**WINE COUNTRY DRIVE (MR220): HUNTLEE NEW TOWN STAGE 1 PROJECT
APPLICATION EXHIBITION**

I refer to your letters dated 15 March 2011 (Your reference: Huntlee New Town Stage 1 Subdivision) and your email of 16 March 2011 regarding the subject project application, referred to the Roads and Traffic Authority (RTA) for comment. I also refer to the RTA's response to the State Significant Site exhibition dated 29 October 2010.

Appendix 3 Preliminary Wine Country Drive Details

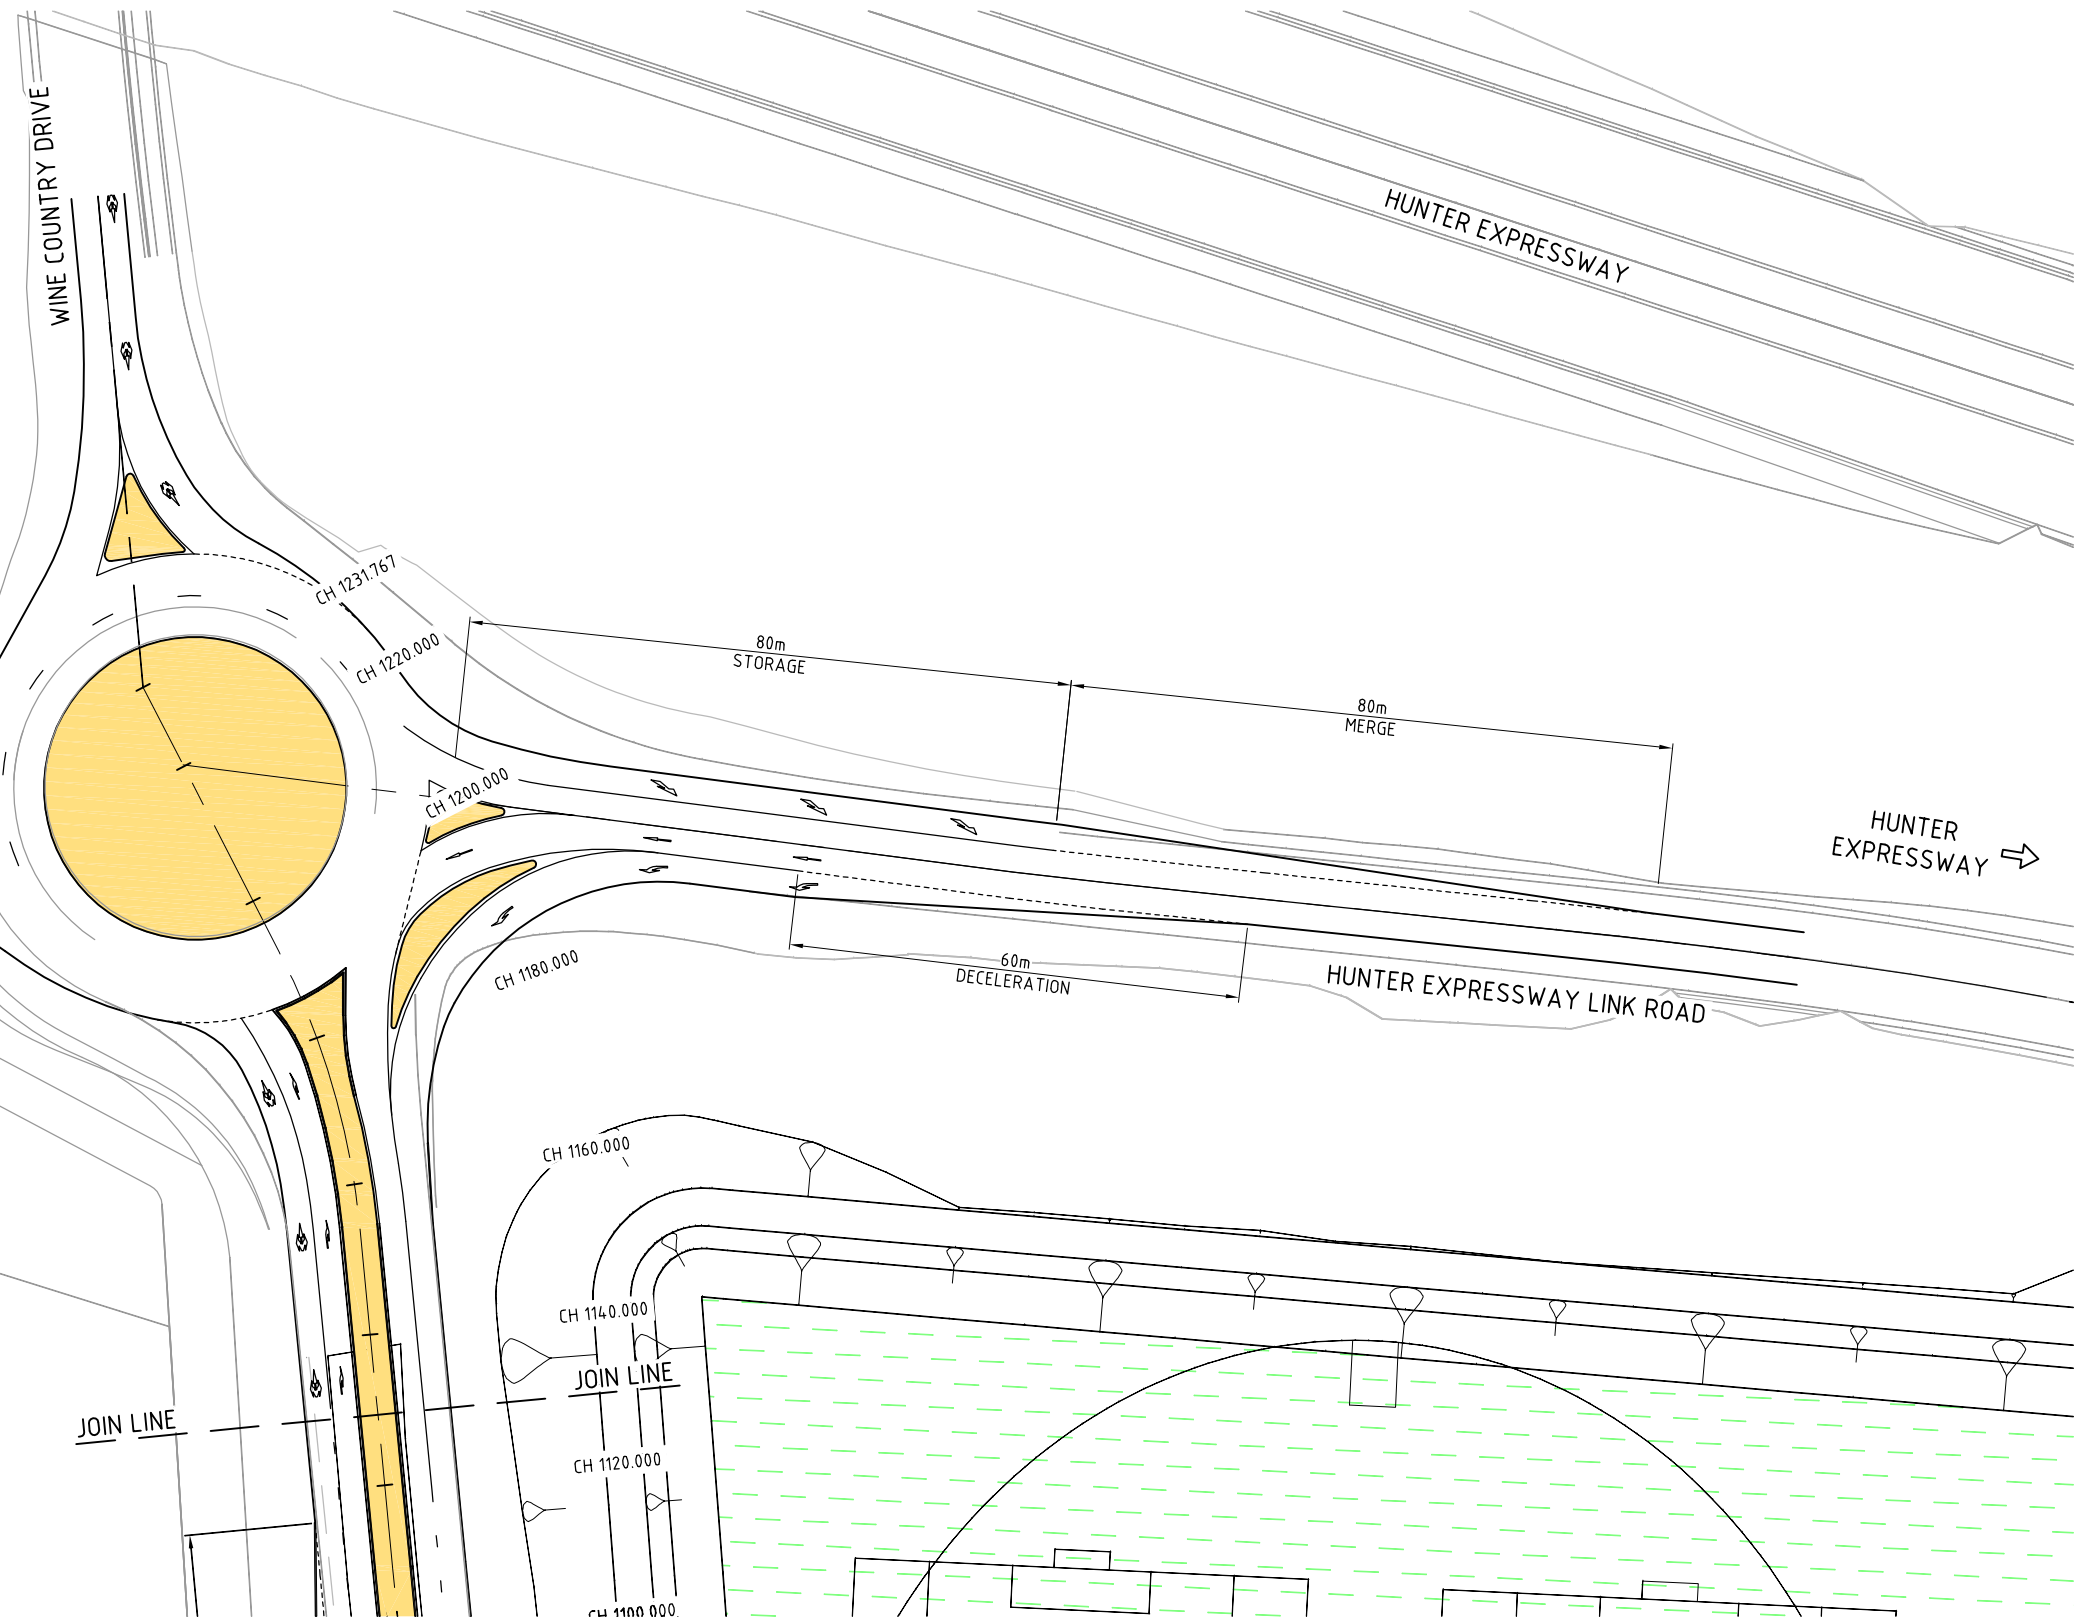
- There is significant conflicting information regarding the number, type and staging of accesses / intersections to the site for Stage I and the full development. This information shall be reviewed and a consistent proposal regarding access / intersections to the development shall be provided. Strategic concept plans of all proposed accesses intersections connecting to the State road network shall be submitted to the RTA for review.

- Preliminary concept plans of any works proposed in connecting to or on State roads shall be provided for RTA review and acceptance.
- There appears to be no vehicular access to the proposed recreational facility on the corner of Wine Country Drive and the Hunter Expressway link road. Concerns are raised about potential parking and congestion issues on State roads due to its current location. It is recommended the facility is relocated to a more appropriate site.

- Given the deficiencies listed above, a review of the strategic concept designs submitted has not been completed. As a minimum, it is expected that the principles of the RTA's *Growth Centres Road Framework* are incorporated into the design of the proposed development. Also, all strategic concept designs shall comply with the requirements of the Austroads *Guide to Road Design* (plus RTA supplements) and the RTA's *Traffic Signal Design*.
